Subject: Fw: To be posted on the Planning Portal Web Site under AL/9/21/DOC Construction Management Plan.

Subject: Land West of Fontwell Avenue AL/9/21/DOC

We wish to make an objection to AL/9/21/DOC for Planning Permission
AL/122/17/PL

CMP plan

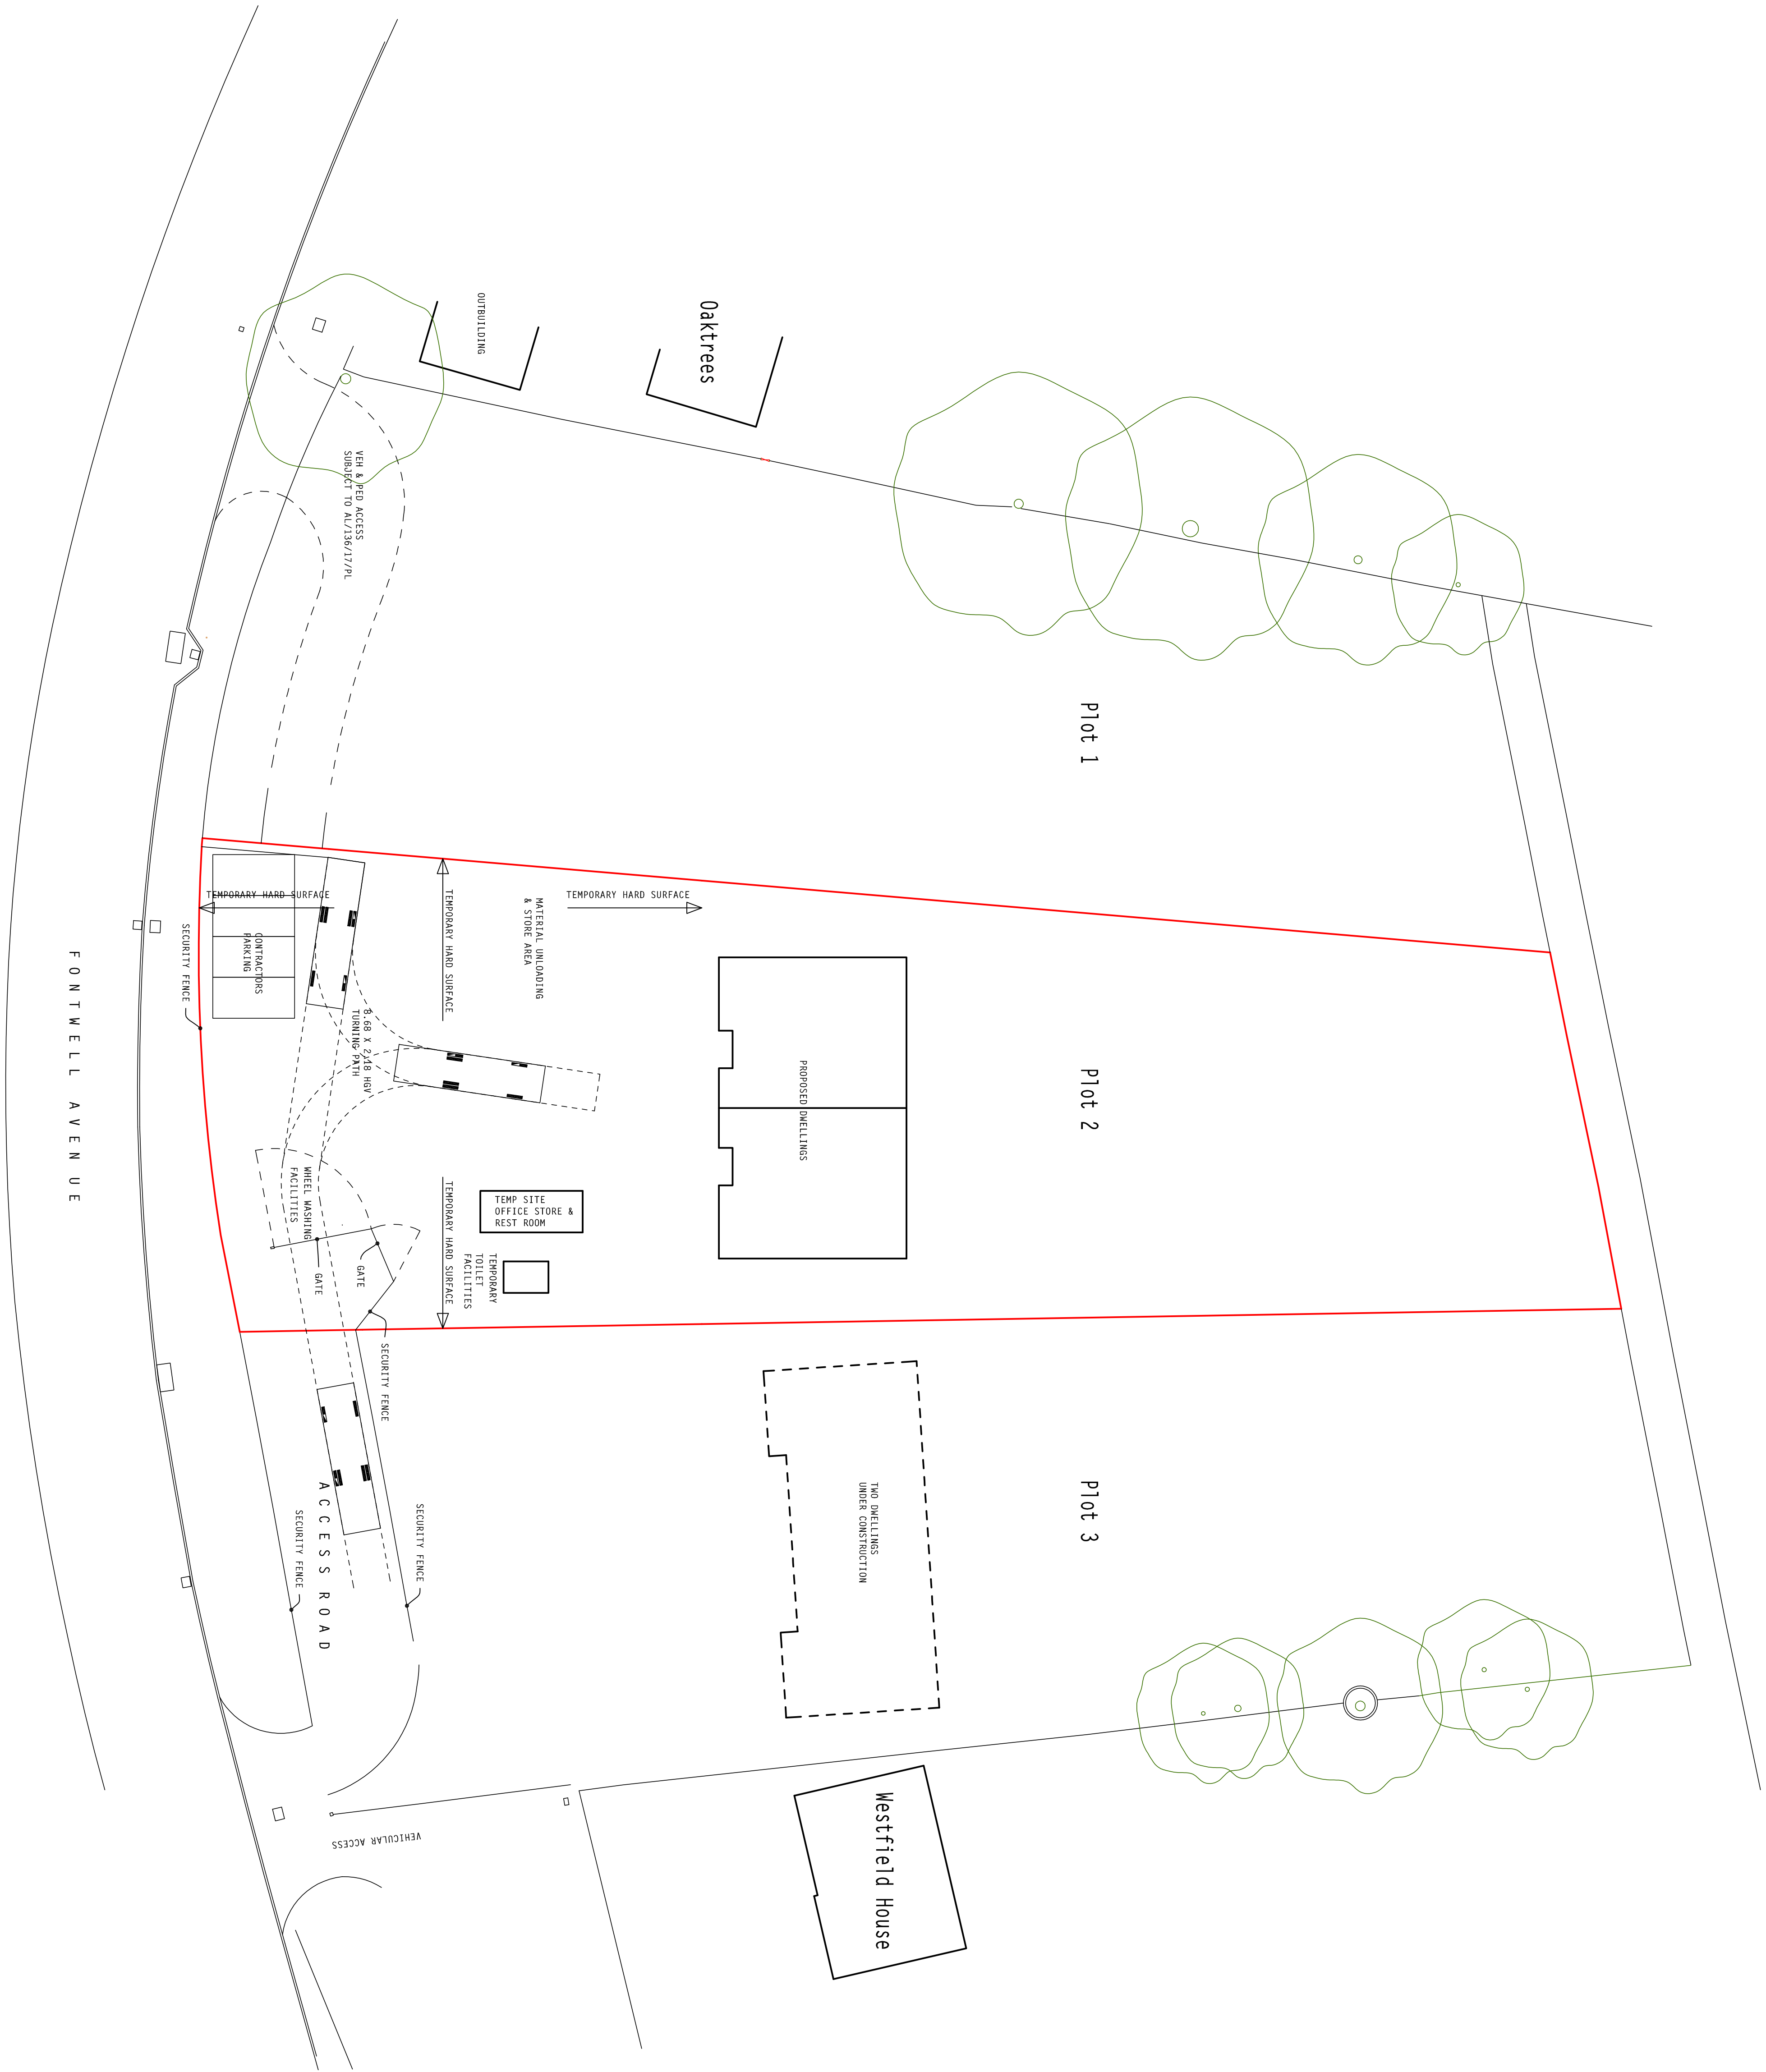
3. 'The site is to be made secure with Heras fencing and the access gates shall be solid boarded gates with a security chain and substantial padlocks. The security shall be constantly monitored, managed and maintained.'

The said gate has been in place now for several weeks and is clearly not doing the job promised in the document, as can be seen from the photographs below. The van and trailer carrying the digger (going out on hire to another site) is able to pass unheeded between the gate and the site fencing as could any other vehicle, because the gate is not secured properly, to the fence on either side of it.

The Heras fencing along the front of the site has already been there for four years and the planning conditions require a maintenance plan for this fencing. There is also no information in this document to shown how the site to the north and south will be made secure. (Presently open to two other sites belonging to two separate individuals and often filled with other vehicles.)
